application number 2023/91527 at location 31, Chapel Hill, Linthwaite, Huddersfield, HD7 5NJ  
16 June 2023 18:36:59

Top Hung
Steelyte® II

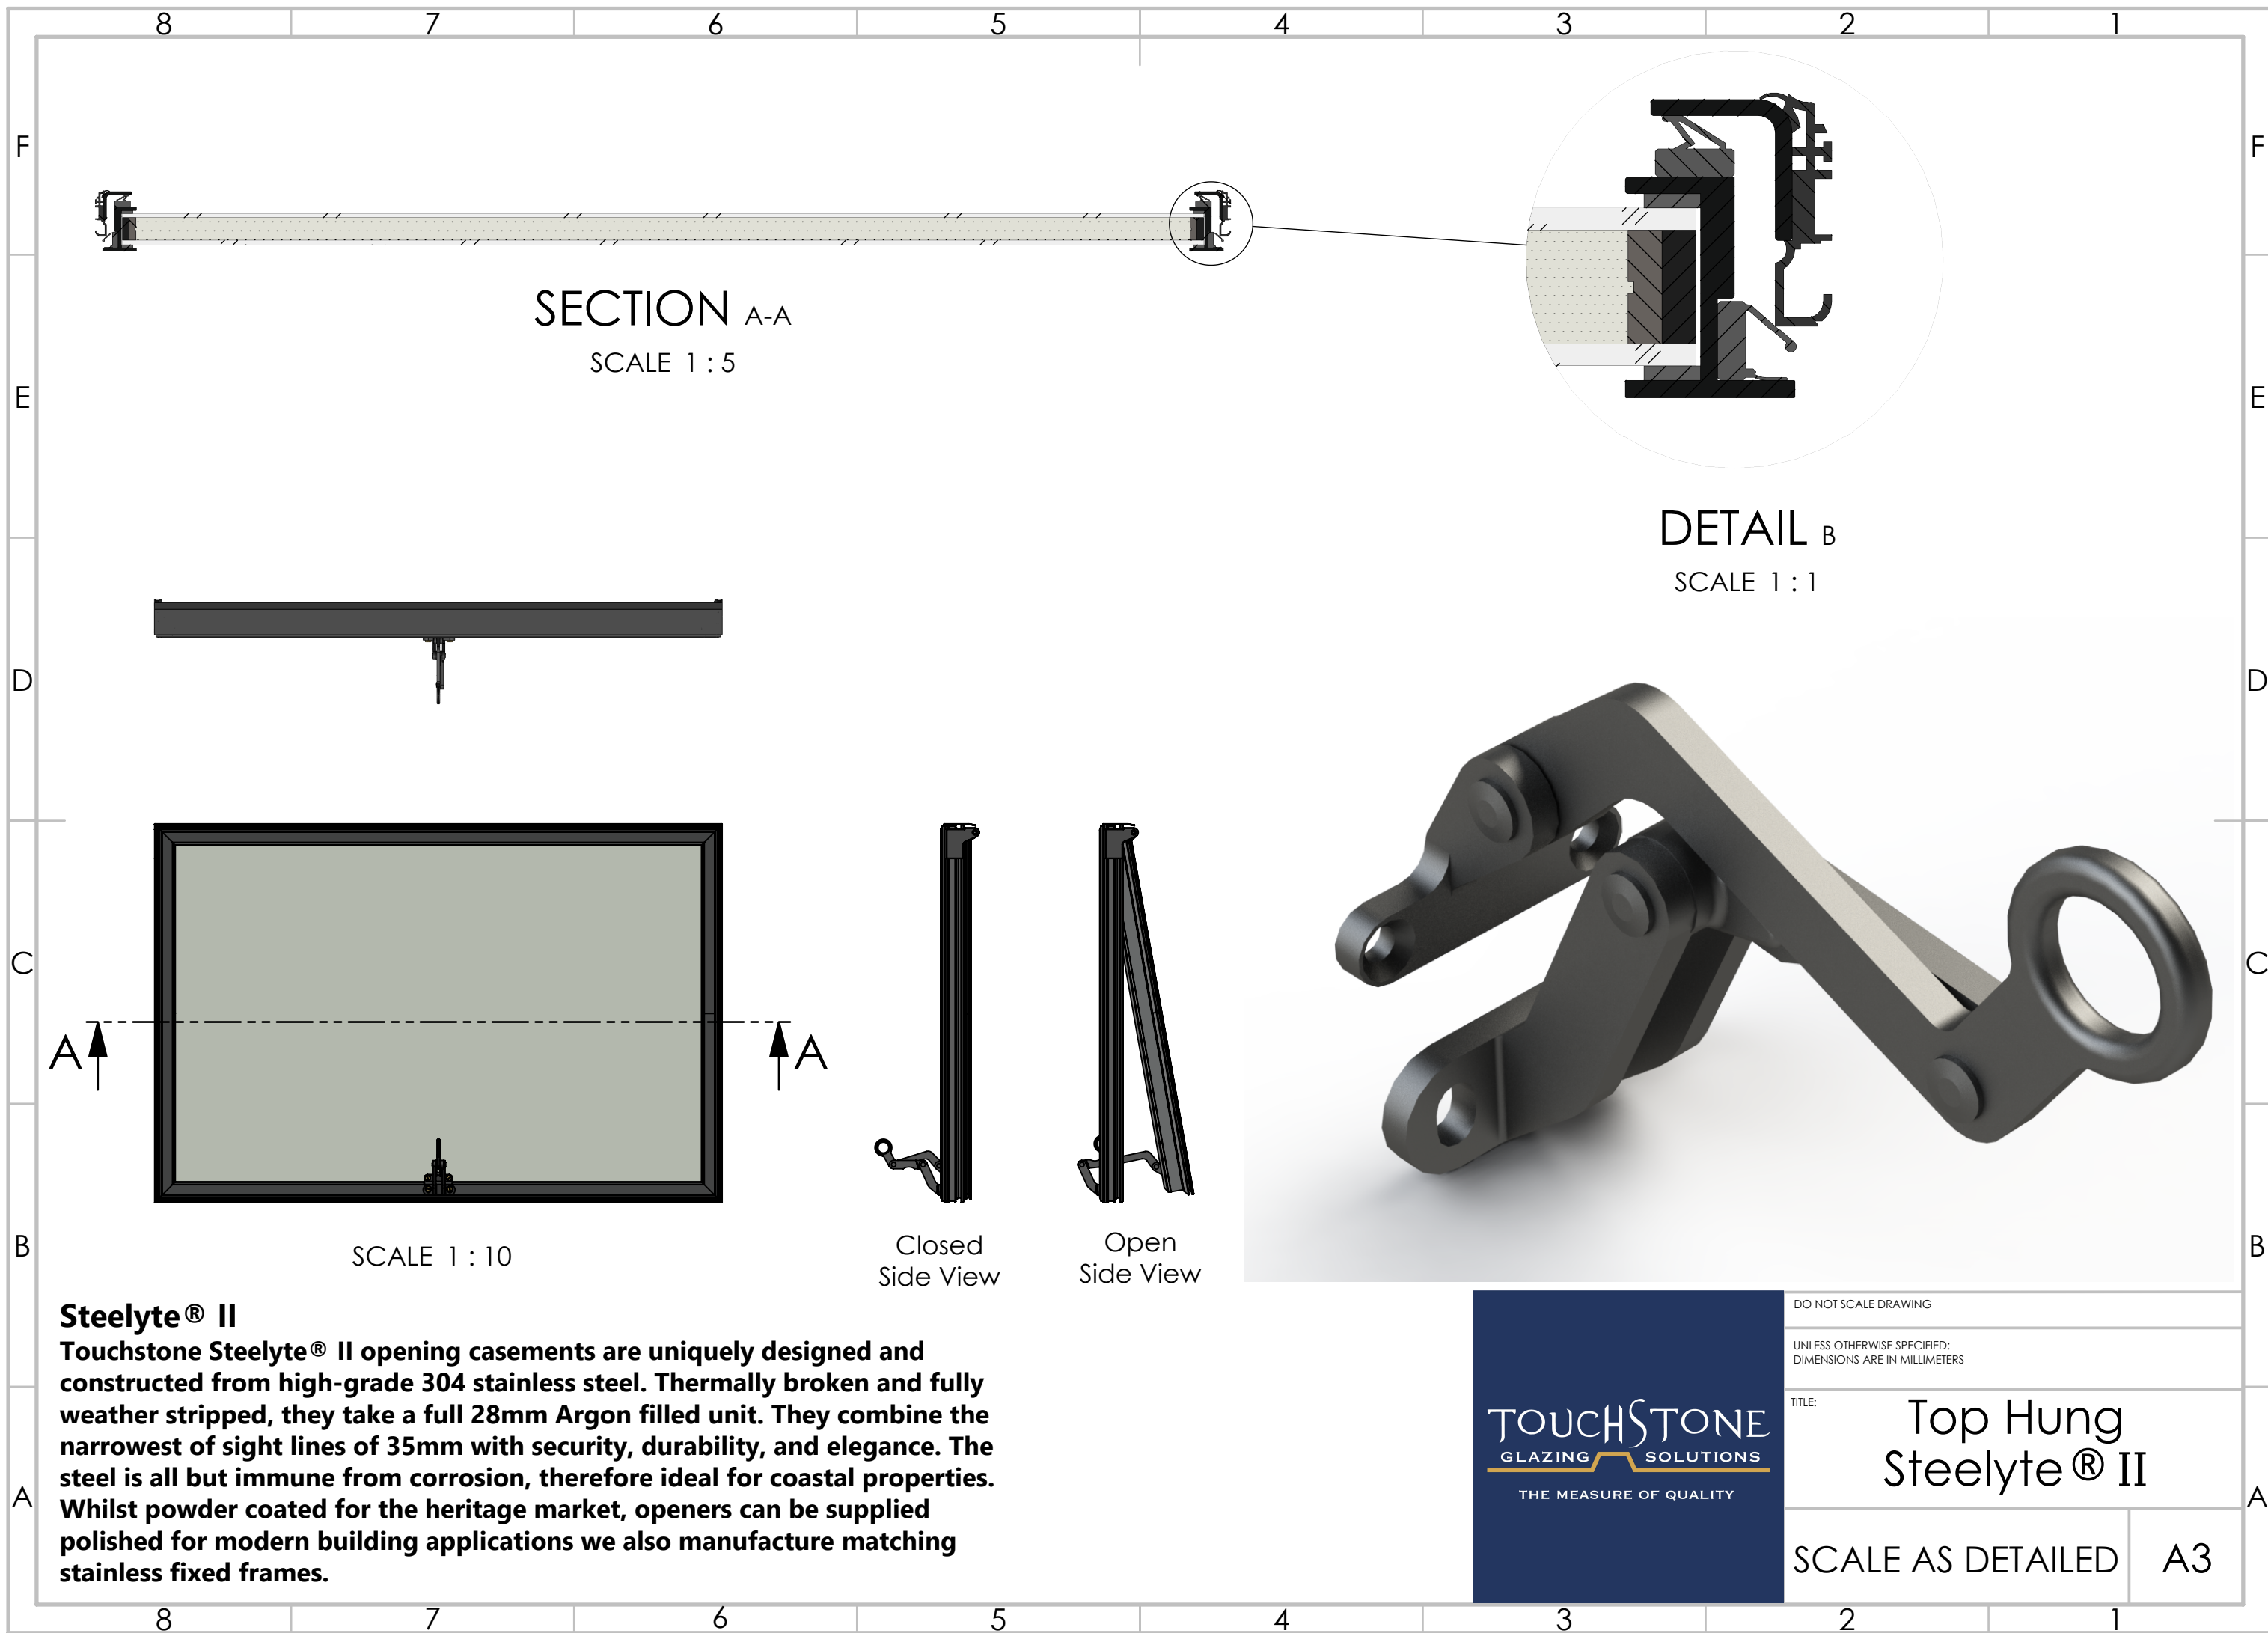
2. We note the present mix of windows and the intention to replace nearly all of them and to rehouse two of them in a lightbox.
  - a) We do urge that any new windows follow a casement or sash form rather than having central top-hung openers shown. The latter would spoil the clean lines of the exterior especially if the different owners open them differentially ( as they are bound to do ).

Drawing:
 Proposed
 Elevations &
 Sections

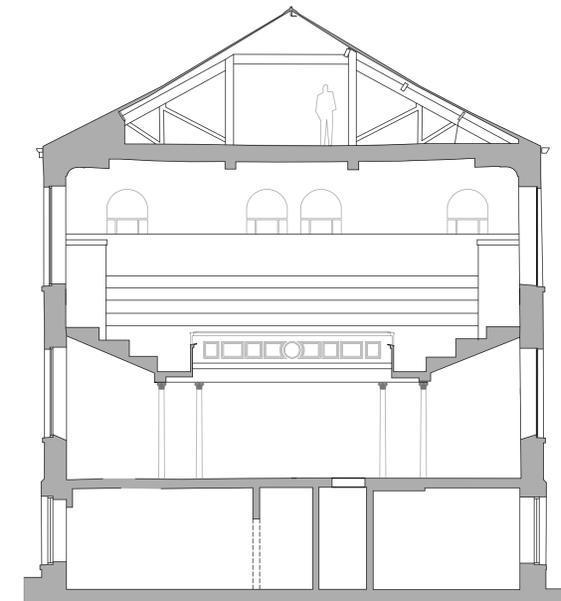
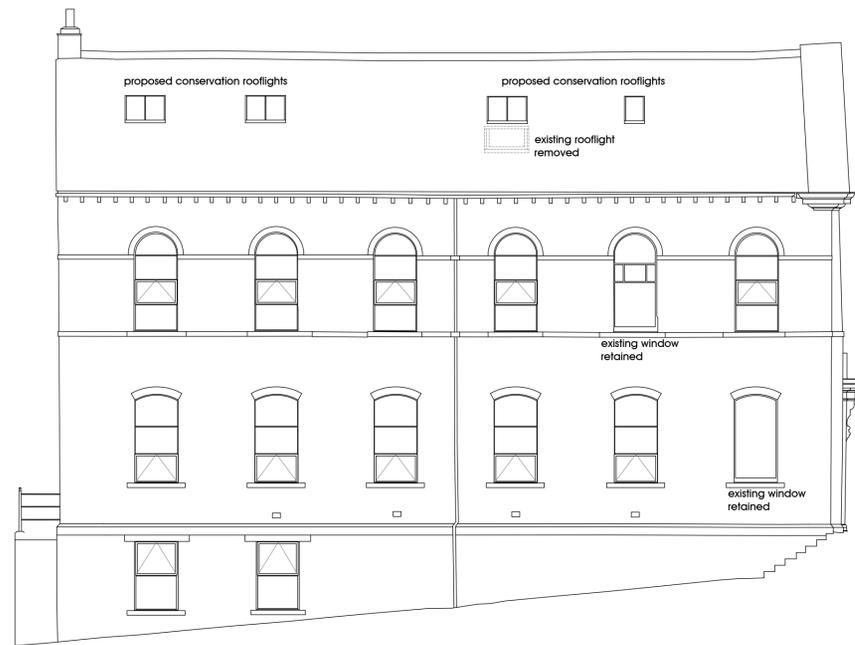
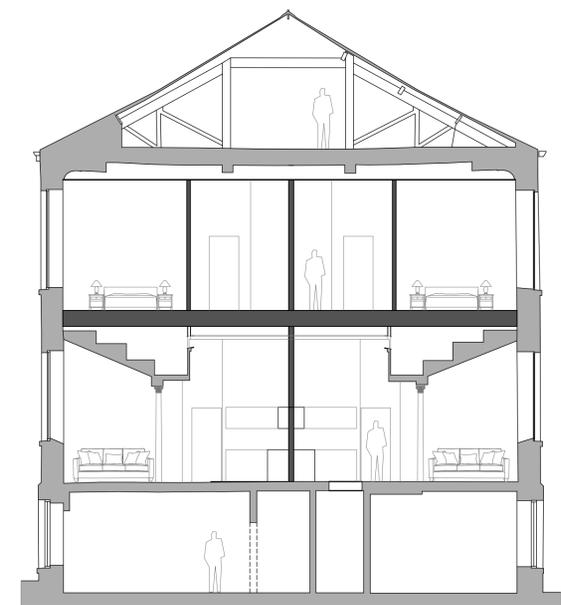
- c) Photo 11 in the same Statement shows the quality of the more of the windows – delicately Classical with a gentle colour palette that admits a great deal of natural light. Should not the presumption lie with their retention ( with modification ) ?

although the inserted floor will inevitably compromise the appearance of the gallery. But might we ask whether a structural engineer has established that the shell, into which we presume that the new floor will be trenched, can take the loading ? It is of course essential that no extra loading is placed on the cast iron columns. Is there to be any means of access ( for maintenance and inspection ) to the enclosed stretches of tiered gallery flooring ?
